TO: Zoning Board of Appeal Chair and Members

FROM: Marge Schmuckal, Zoning Administrator

SUBJECT: Lot #2 Morningstar Lane – 385A-A-032

DATE: August 1, 2013

# Plot Plan, Lot #2, Morningstar Lane

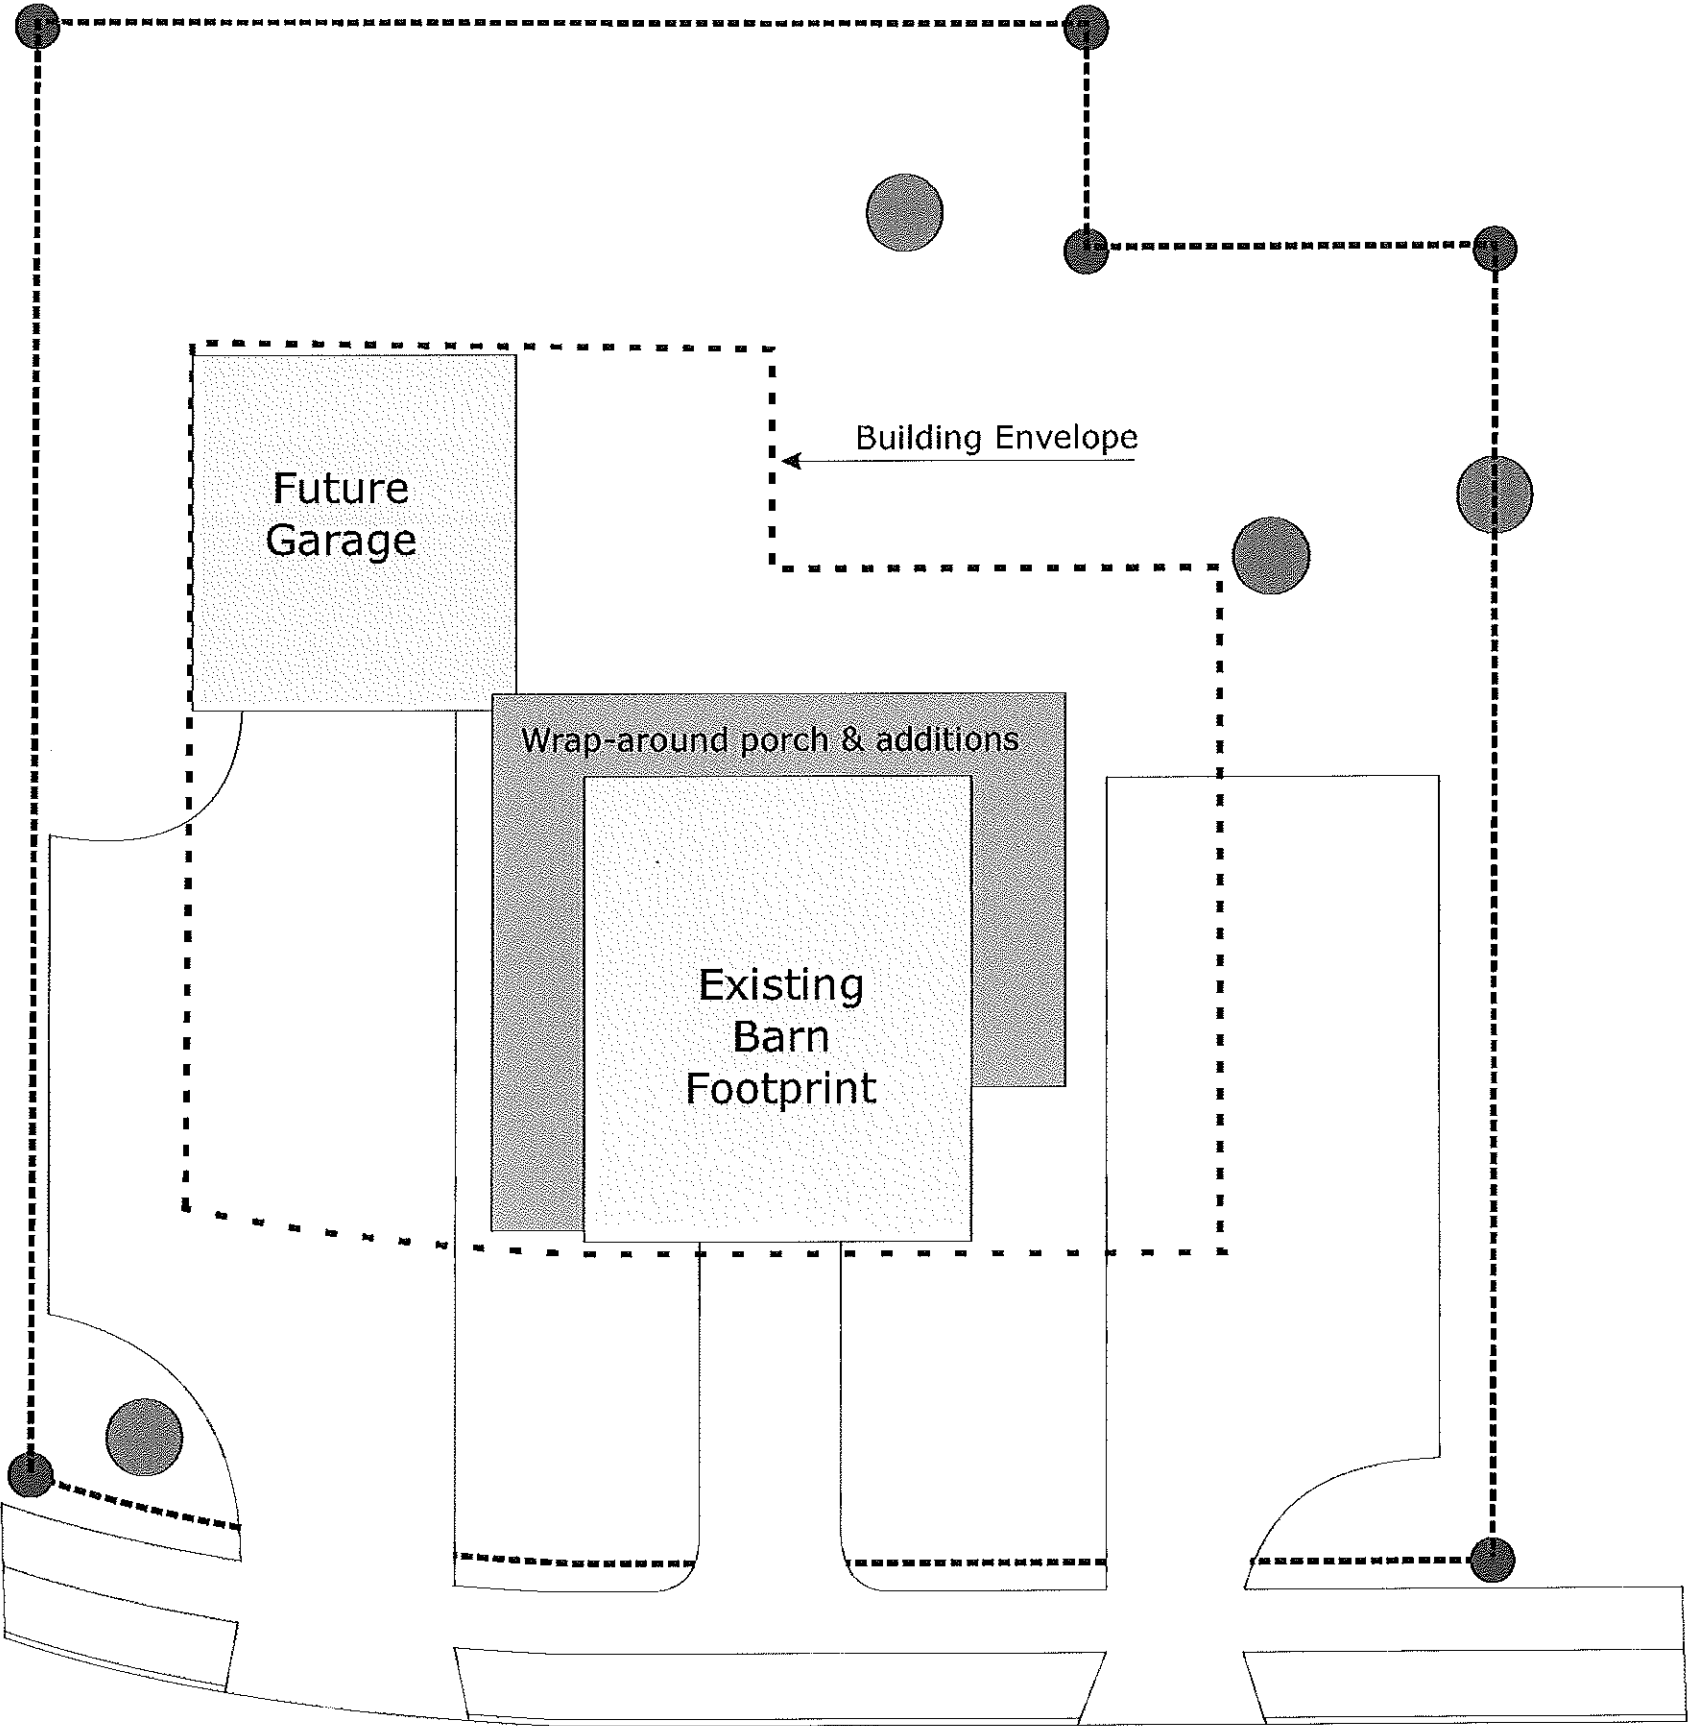
It has come to the City's attention that there may be items on the submitted plans before you that would not meet other City requirements, such as two separate curb cuts for one lot and the number of proposed parking spaces. Those issues and others will be addressed with the subsequent review(s). It is my understanding that if the Board approves the conditional use appeal, it is not approving by default any other items shown on the applicant's plans that are not part of the conditional use requirements and standards.
